February 22, 2007

Re: PNM Mesa del Sol Substation Grading Plan

Engineer's Stamp dated 2-9-07 (R16/D002B) R16/DA3003

PNM PUBLIC SERVICE COMPANY OF NEW MEXICO		
MESA DEL SOL SUBSTATION DRAINAGE PLAN		
SHT: 2 OF 6		
DRW: R.M.	TR:	DATE: 02/08/07
CKD: P.T.B.	OK:	SCALE: 1" = 100'
APP:	ACAD FILE:	USS - 8204
REV. NO.	PNM/MDS

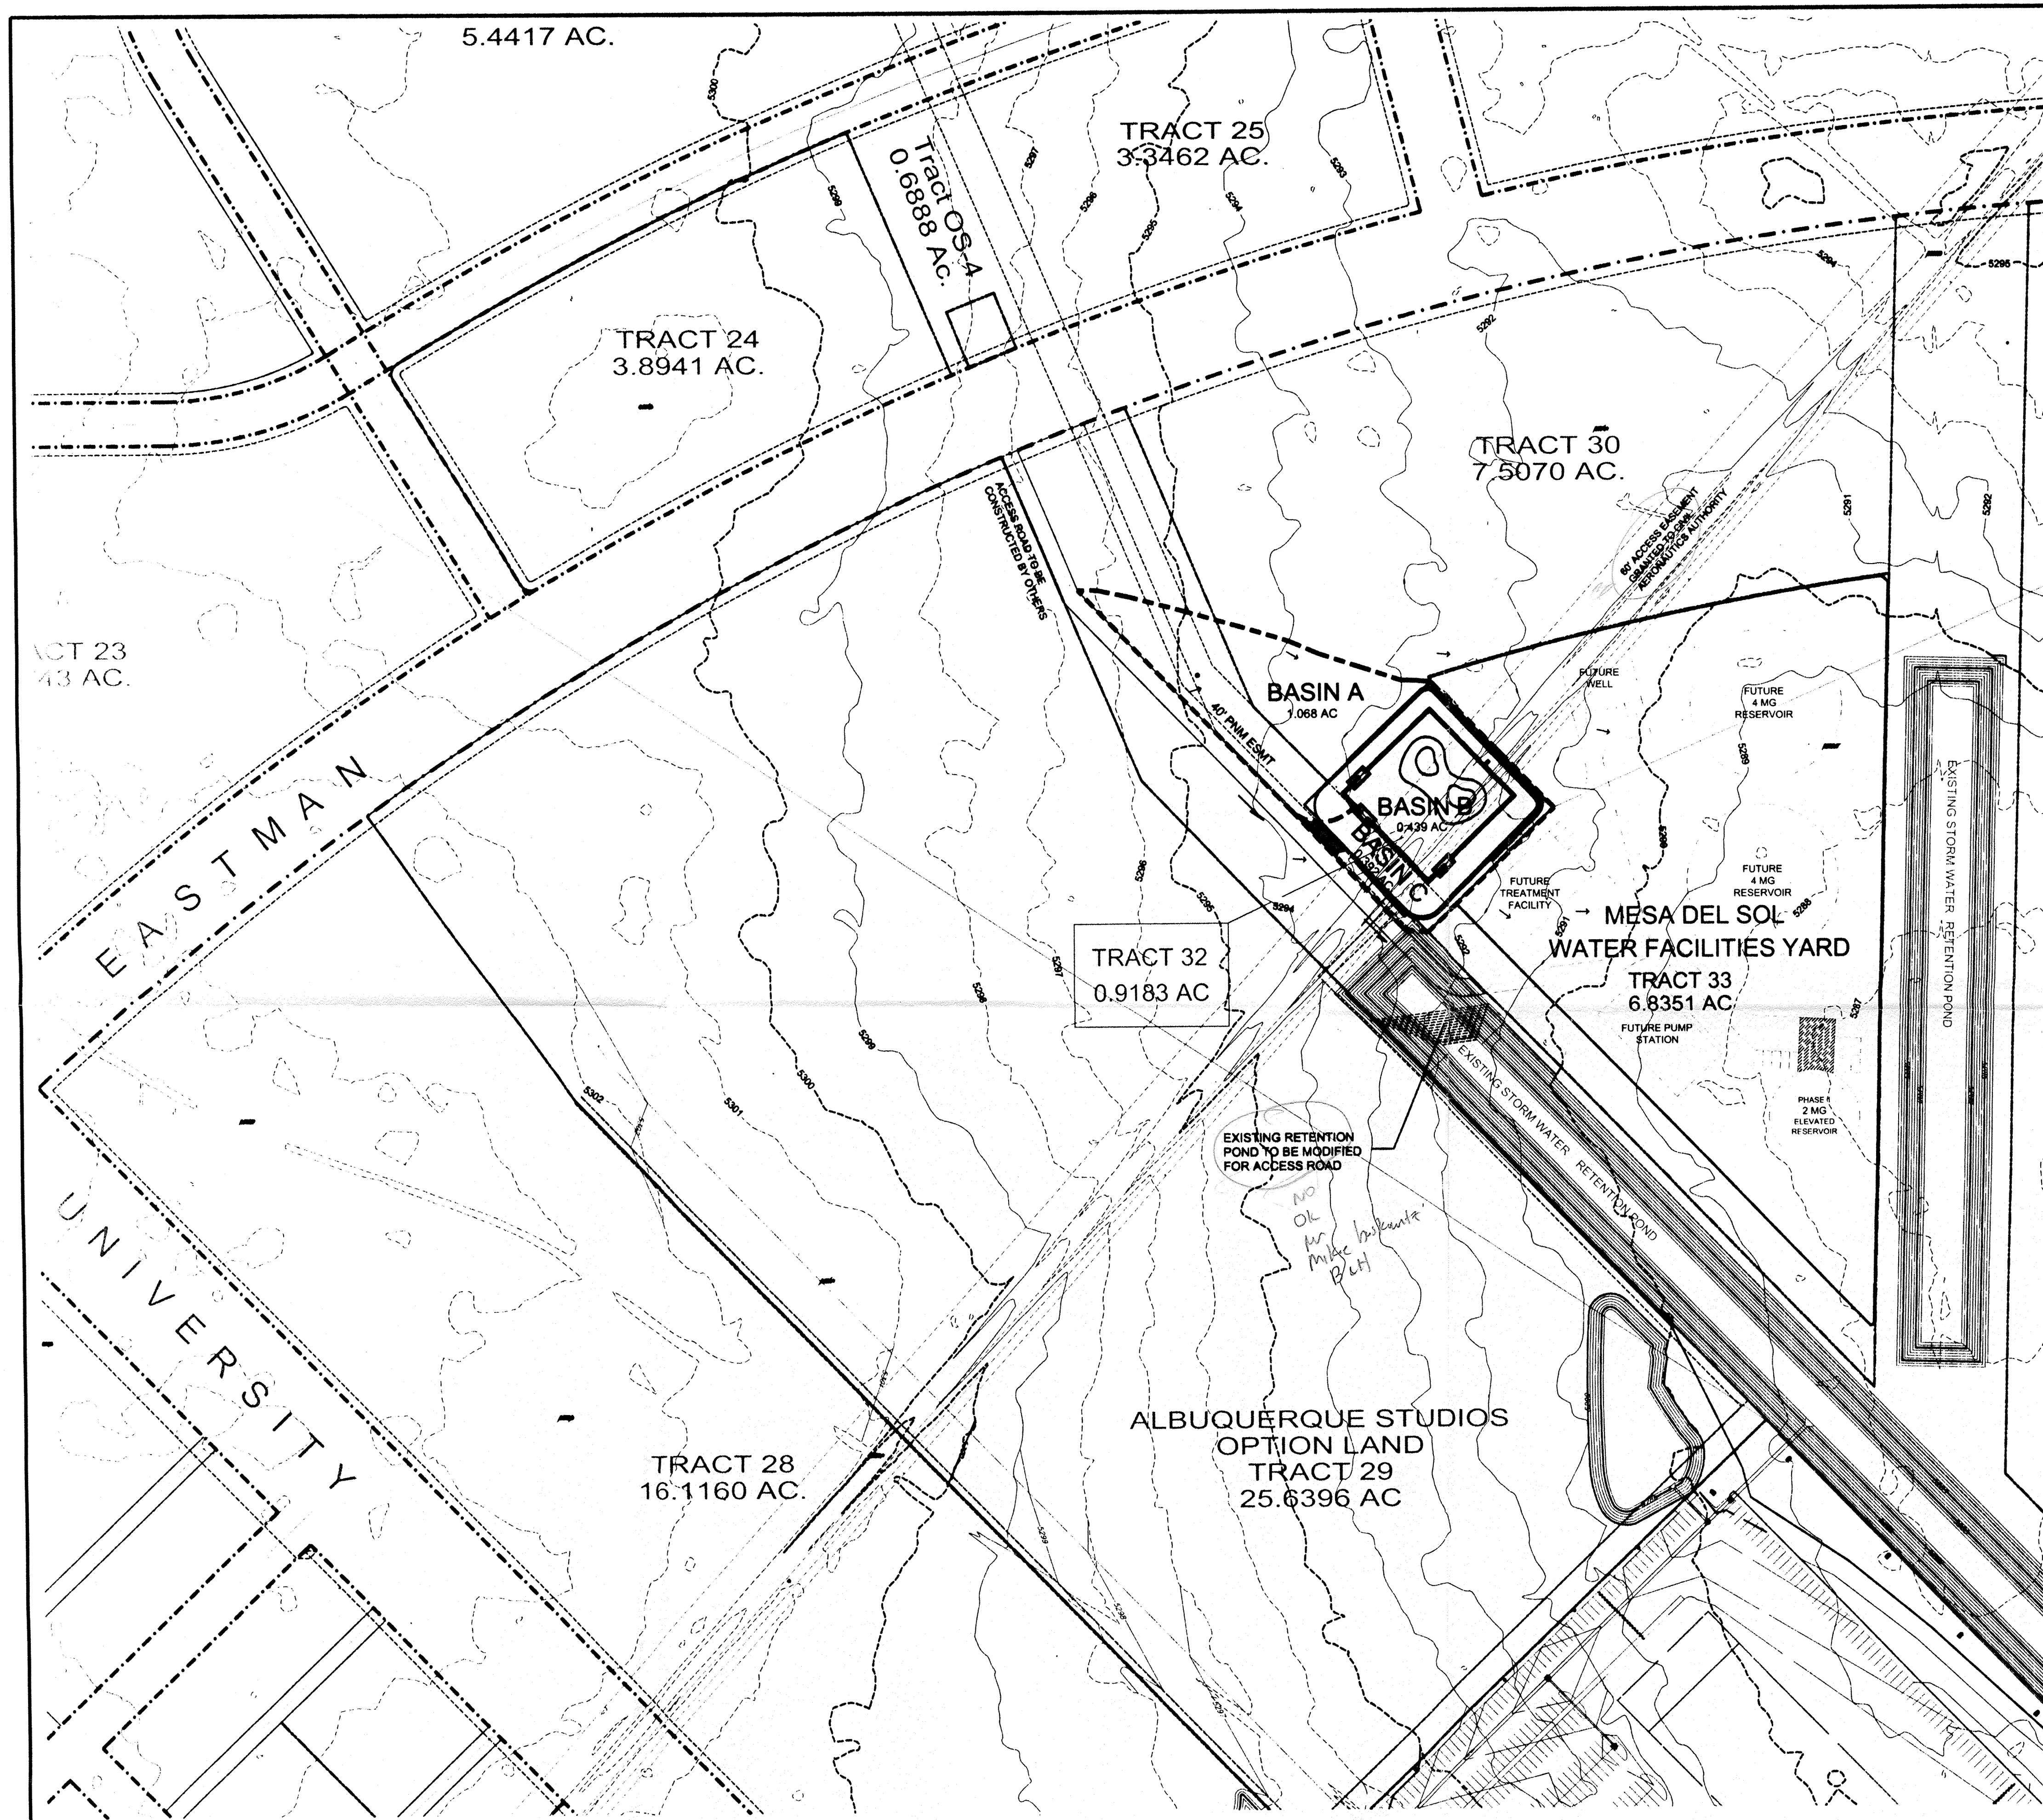
- Provide the ponding volume provided and the water surface elevation inside the enclosure for the 100 yr-10 day storm.
- Provide more detail for the swale on the west side of the road and the modifications to the retention pond.
